Our Ref: BN/59/19/DOC

Approval of details reserved by condition imposed under ref BN/23/15/PL relating to Condition Nos 5 - surface water drainage, 6 - consent for discharge of any flows to watercourses, 7 - future access & maintenance of watercourses or culverts.

Land Adjacent 4 Lake Lane Barnham PO22 0AD

|        | 4 Lake Lane<br>Barnham<br>West Sussex | Surface water<br>drainage plan | Planning    | CB       | CB             |

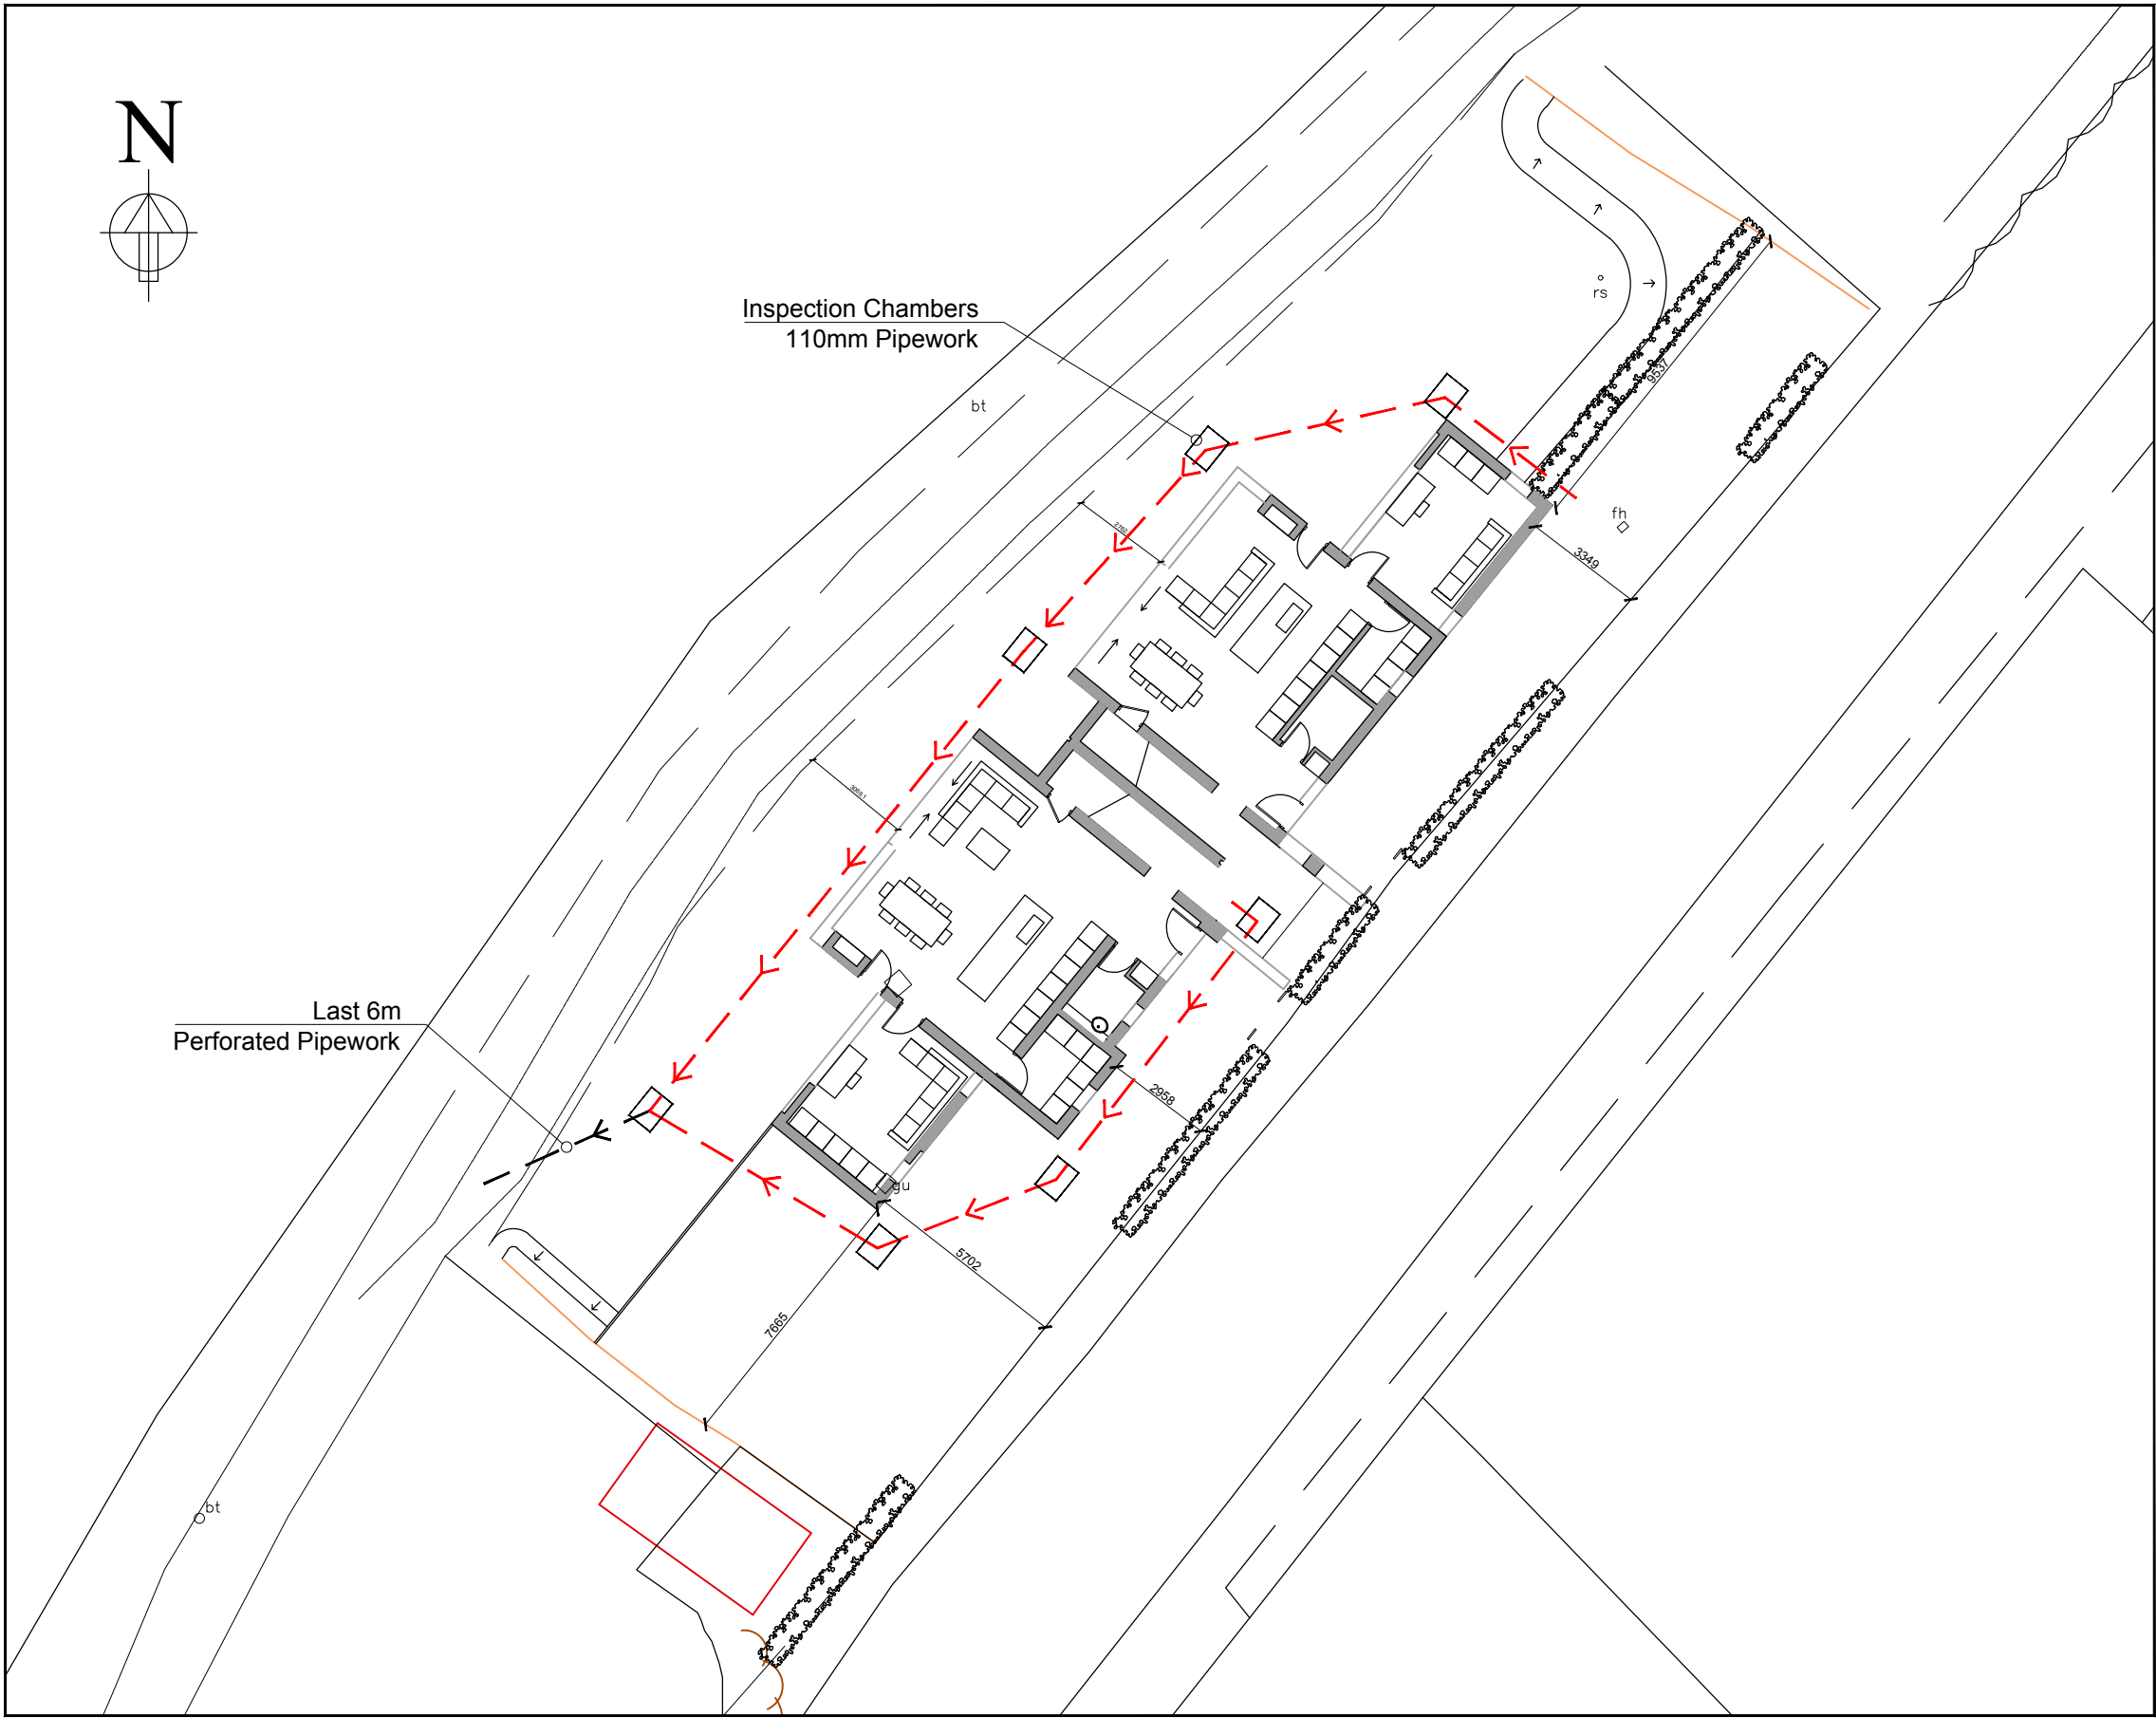
The condition cannot be discharged as the Council's engineers have stated the information submitted is not sufficient to satisfy the Council that the proposed scheme is adequate to effectively drain the site.
